City of Portland, Maine - Building or Use Permit Application

Permit No: 10-0521	Issue Date:	CBL: 321 A001001
------------------------------	--------------------	----------------------------

Past Use: Vacant Land	Proposed Use: Commercial - Build new 12,000 sq ft pre-engineered metal building for metal recycling use and office area	Permit Fee: \$4,745.00	Cost of Work: \$465,000.00	CEO District: 5
Proposed Project Description: Build new 12,000 sq ft pre-engineered metal building for metal recycling use and office area		FIRE DEPT: <input type="checkbox"/> Approved <input type="checkbox"/> Denied	INSPECTION: Use Group: Type:	
		Signature:	Signature:	
PEDESTRIAN ACTIVITIES DISTRICT (P.A.D.)				
Action: <input type="checkbox"/> Approved <input type="checkbox"/> Approved w/Conditions <input type="checkbox"/> Denied				
		Signature:	Date:

Dept: Building **Status:** Approved with Conditions **Reviewer:** Jeanine Bourke **Approval Date:** 06/08/2010

WALL DETAILS

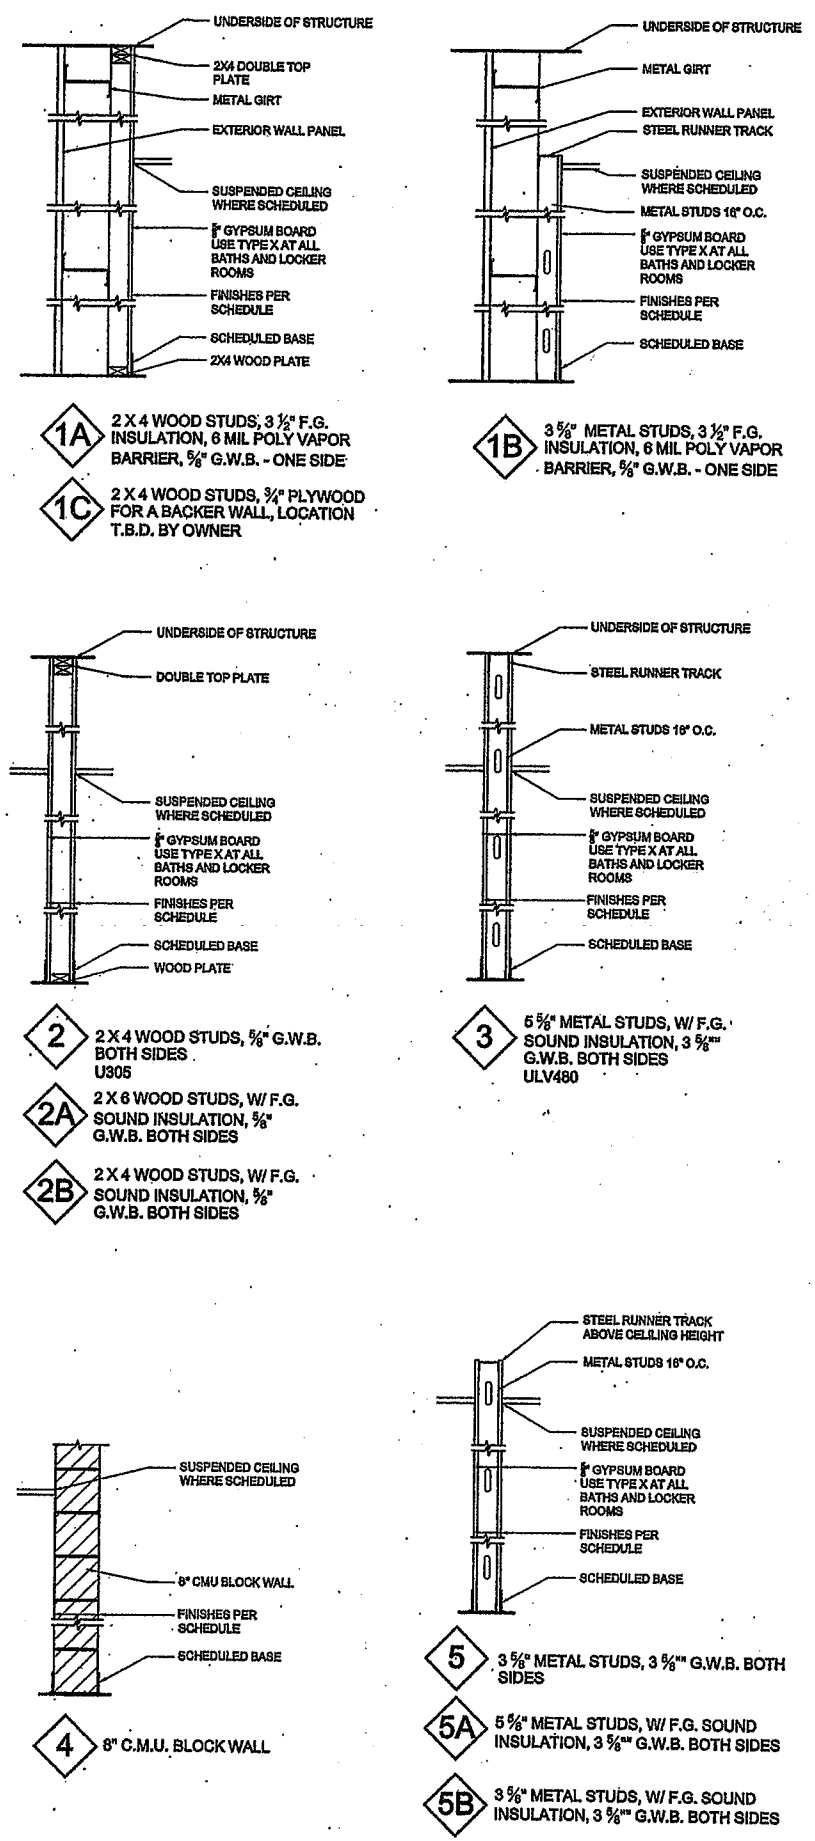
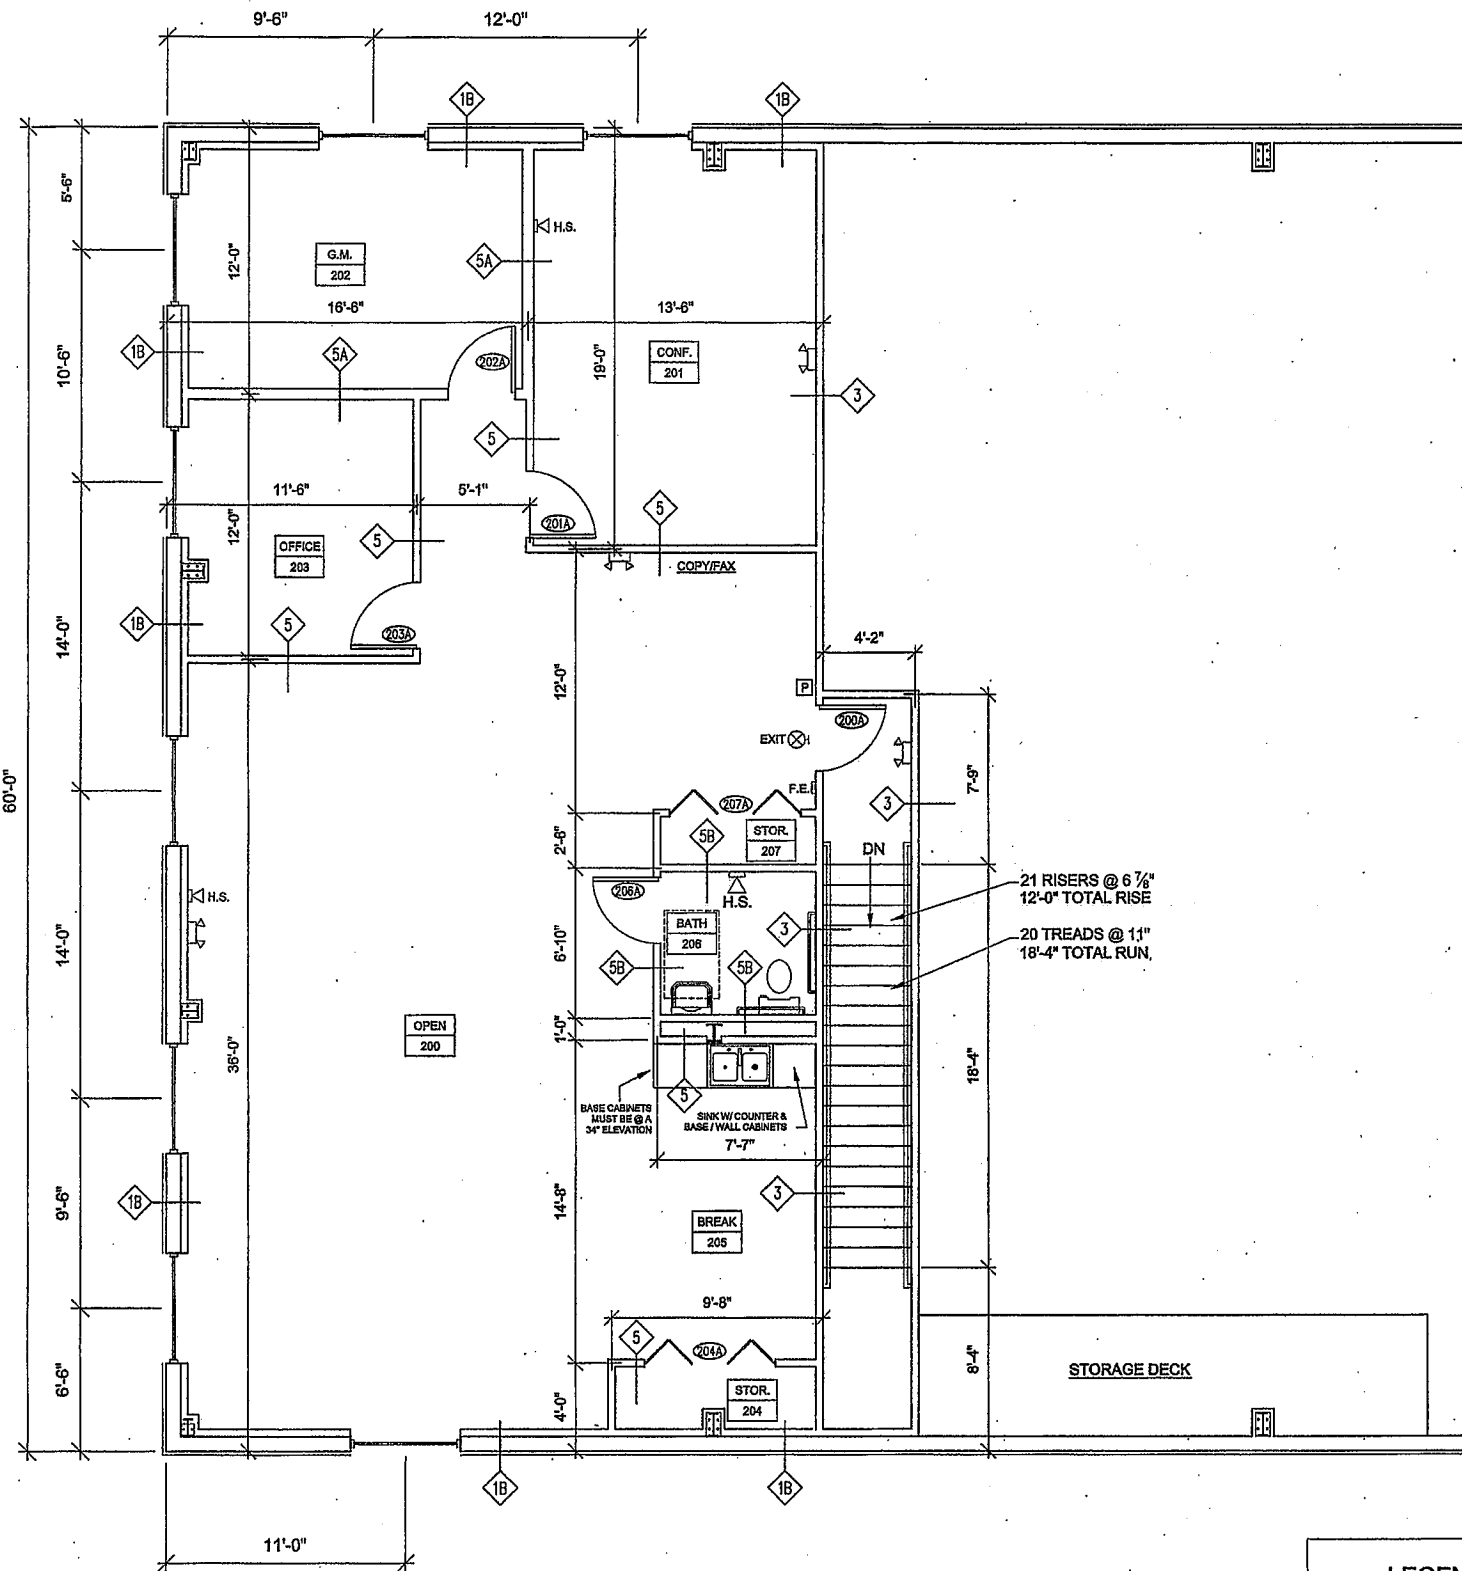
6/1/2010-jmb: Left vcmg for Dennis W. At Patco for initial items needed based on review, 1.consistency of the design application from architect and VP Buildings for use group classification, type of construction, 2.statement of SI does not include list of agents, 3. No geotech report, 4. Wall types are not consistent or not labeled, 5. Need Com Check for IECC.

6/2/2010-jmb: Received submittals regarding review on 6/2 and 6/3
